Recommendation Report for Planning Permission for Works or Extension to a Dwelling

REF NO: BE/144/20/HH

LOCATION: 1 Markfield  
Bersted  
PO22 9HW

PROPOSAL: Retention of attached single storey garage with storage area.

Title
EXISTING AND PROPOSED ELEVATIONS
- NO CHANGE AS RETROSPECTIVE

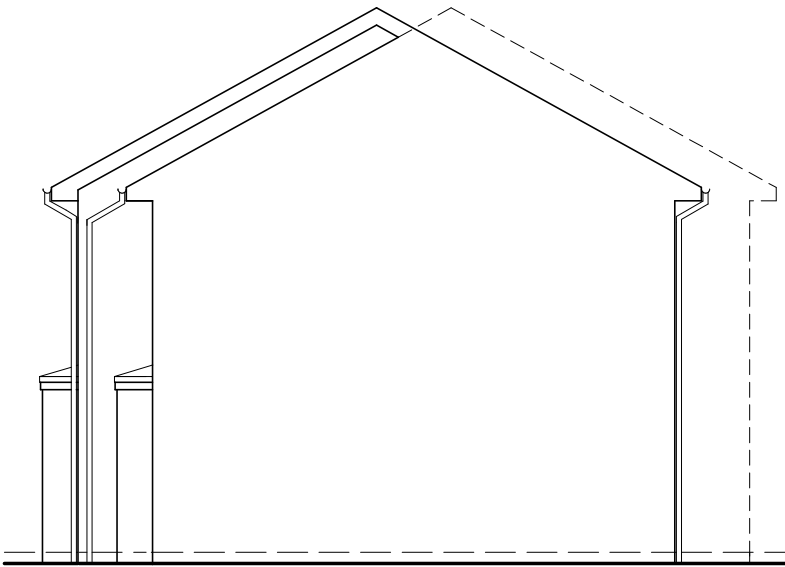
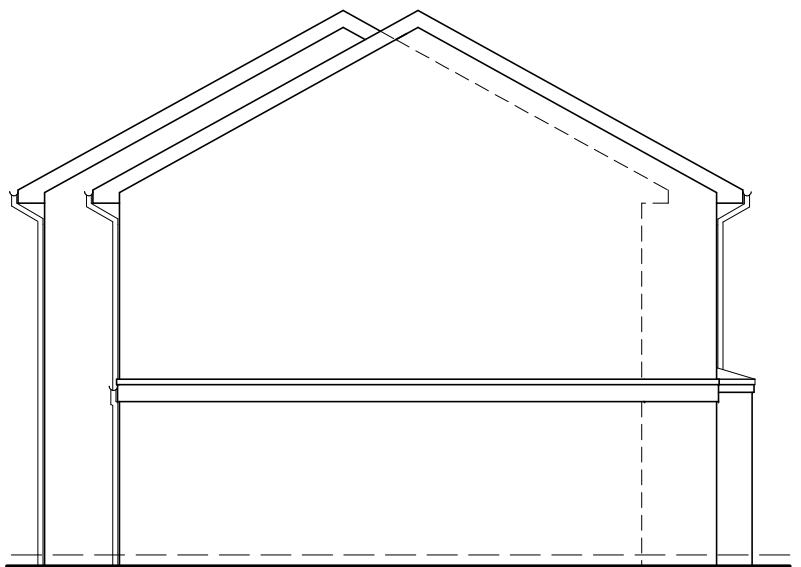
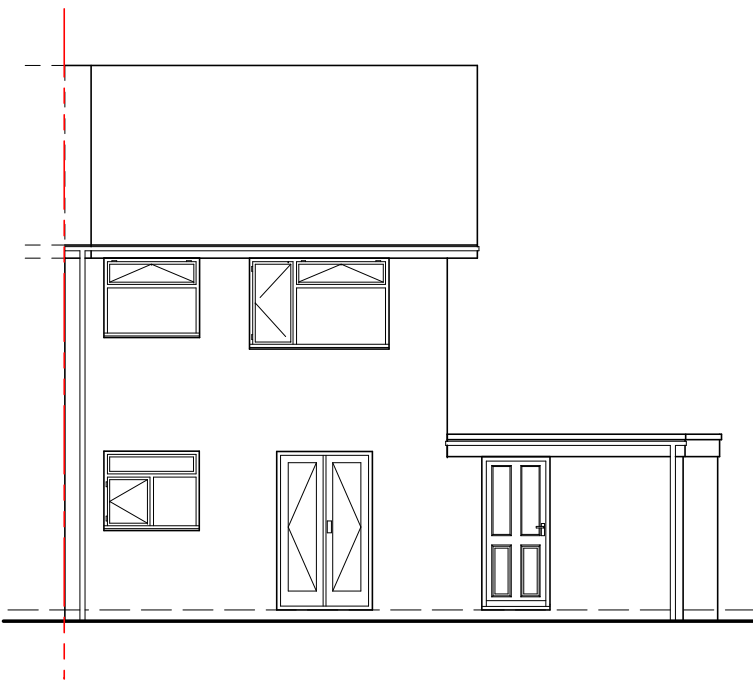
The garage is located to the western elevation and extends up the boundary footpath however is not considered to appear unduly dominant, meeting with the principle elevation.

The materials match the appearance of the host dwelling and as such it appears well integrated.

There is a garage door to the front and an access door to the rear which enters the rear garden of the host dwelling.

Title
EXISTING AND PROPOSED GROUND FLOOR
PLAN - RETROSPECTIVE - NO CHANGE

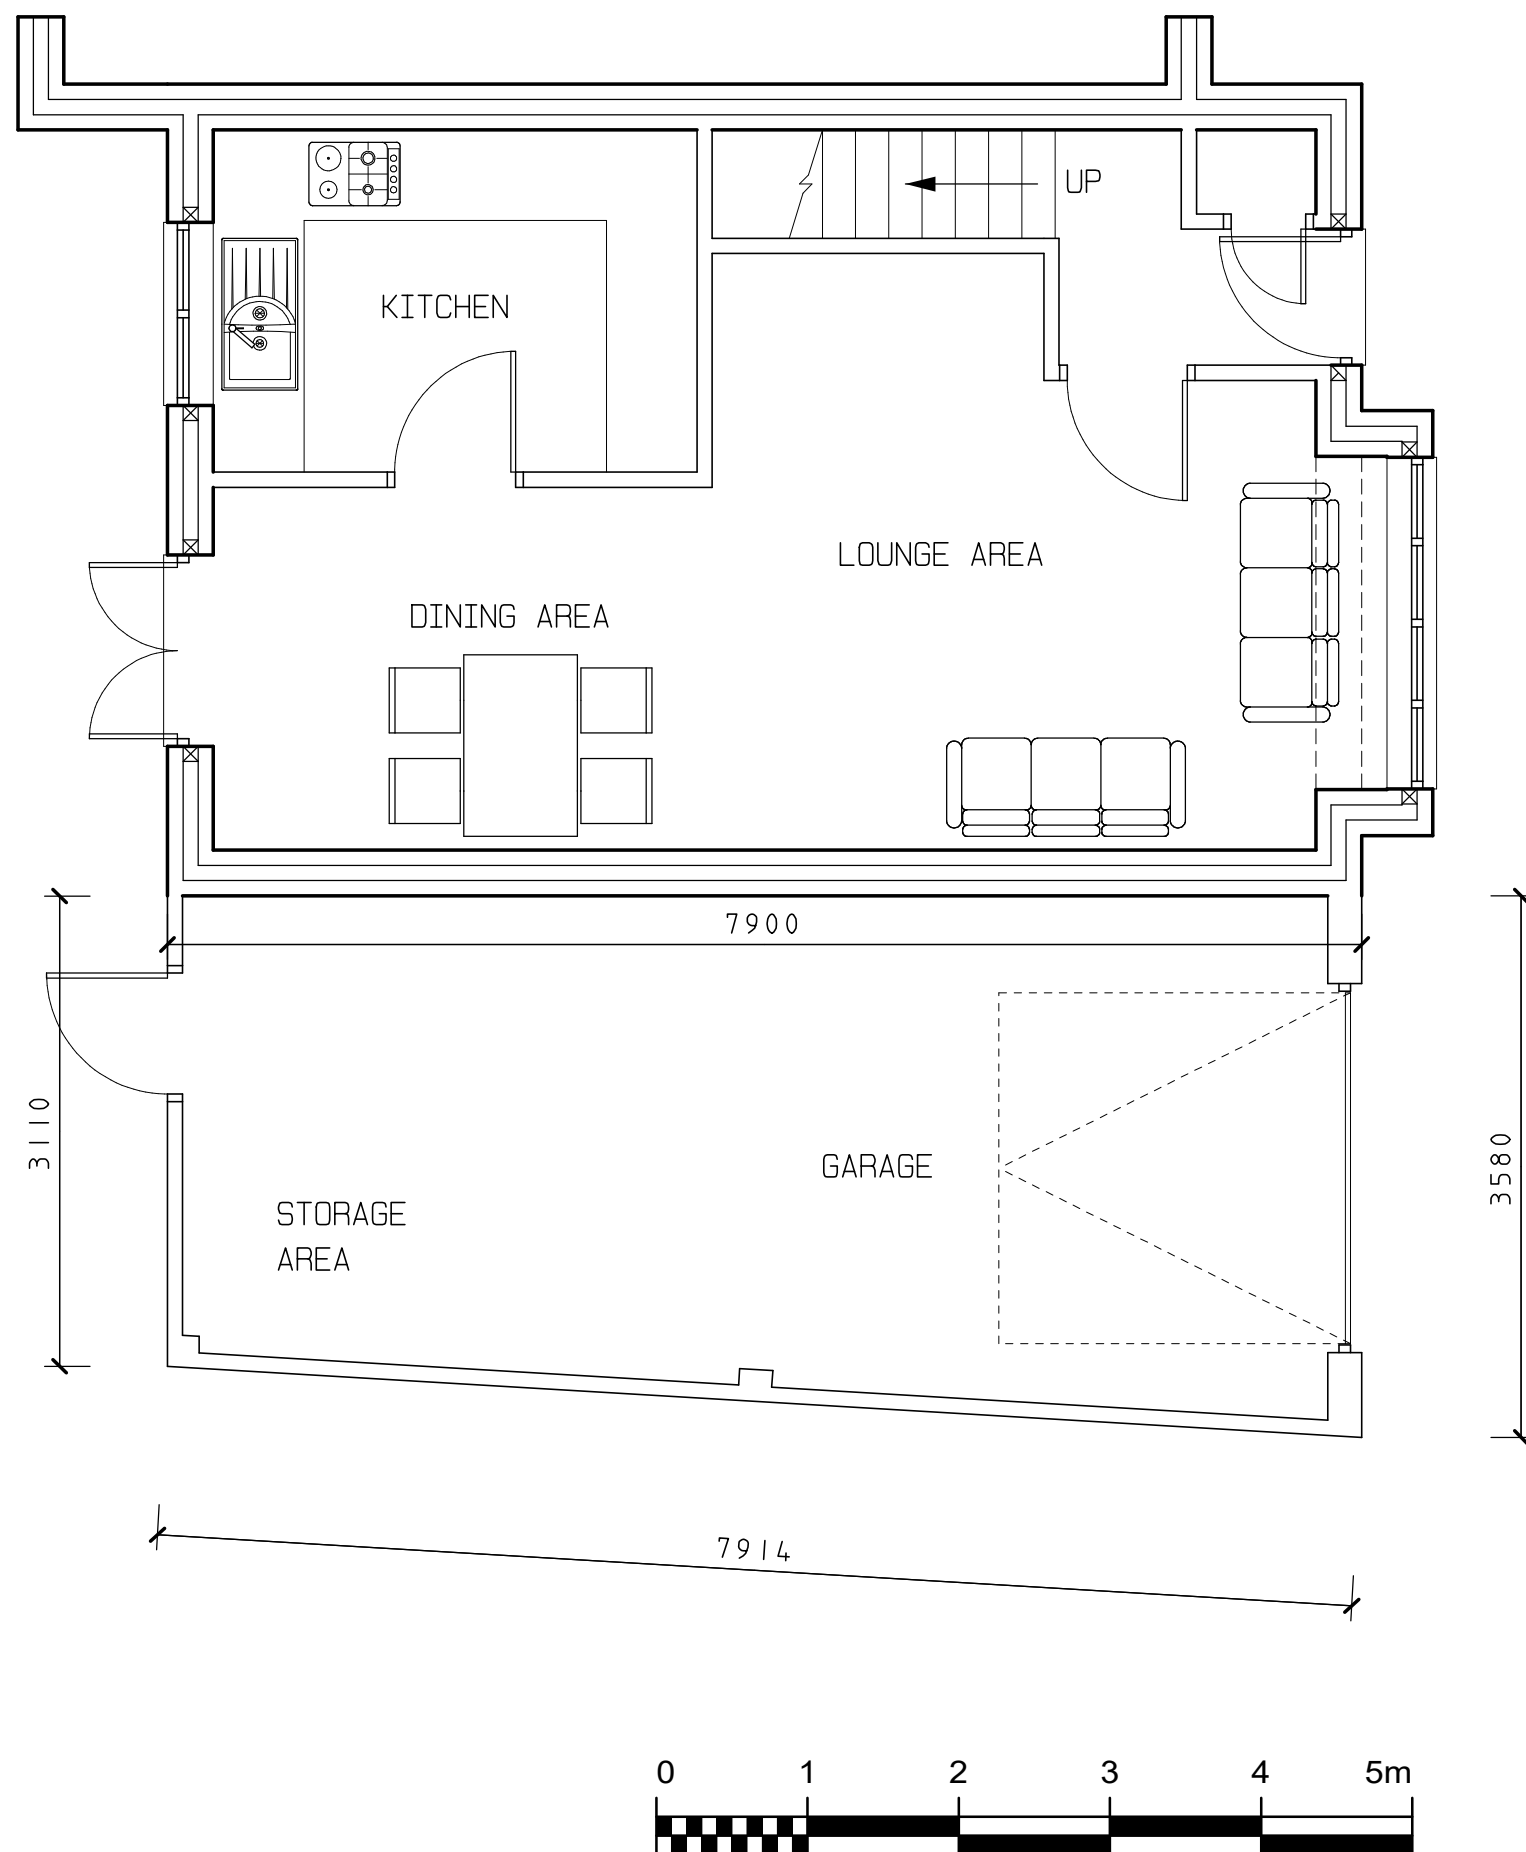
The garage will have a width of 3.5m and a depth of 7.7m where it meets with the rear elevation. It has a flat roof with a height of approximately 2.4m.
